Address: 27 Birklands Road Huddersfield HD2 2PF

Application number: 2025/91229	
What is the application for?:	Erection of single storey rear extension and dormer
Address of the site or building:	29, Birklands Road, Cowcliffe, Huddersfield, HD2 2PF
Postcode:	HD2 2PF

Proposed South West Elevation (Rear)
1 : 50

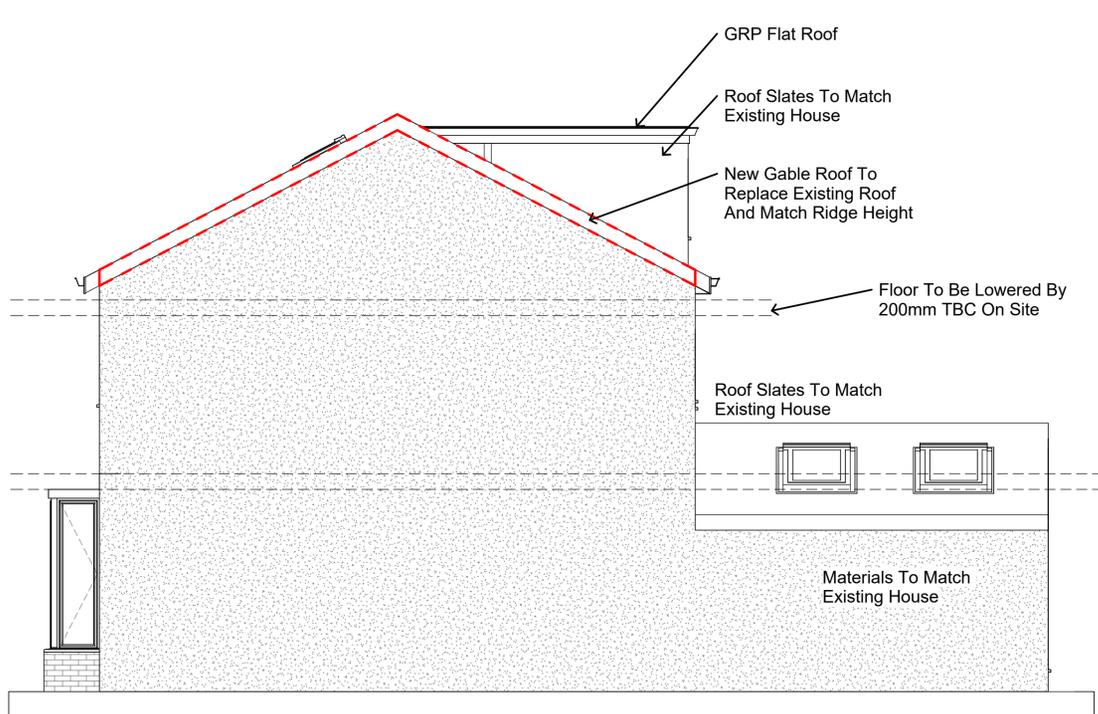
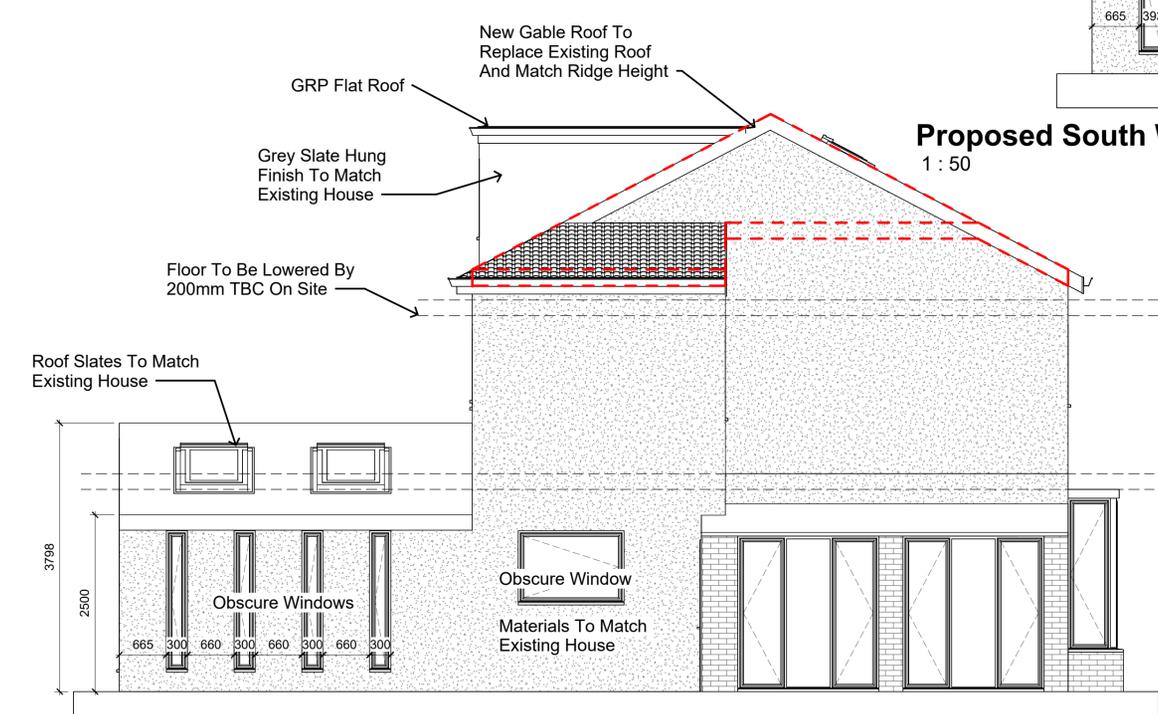
Type of comment: A general comment	
Do you wish your comments to be published on the website anonymously?	No
<p>The windows on the planning application for the extension are listed as being obscure windows but the windows that have been fitted are clear glass. Due to the elevation of the extension we have lost an element of privacy. If the glass was obscured, as per the application, this wouldn't be an issue.</p> <p>Also, a newly created raised area to the rear of the property hasn't been listed on the planning application and has added significant height to the rear of the property, in excess of 3ft. This has also created a lack of privacy as the ground level is now effectively equal to the top of the boundary fence.</p>
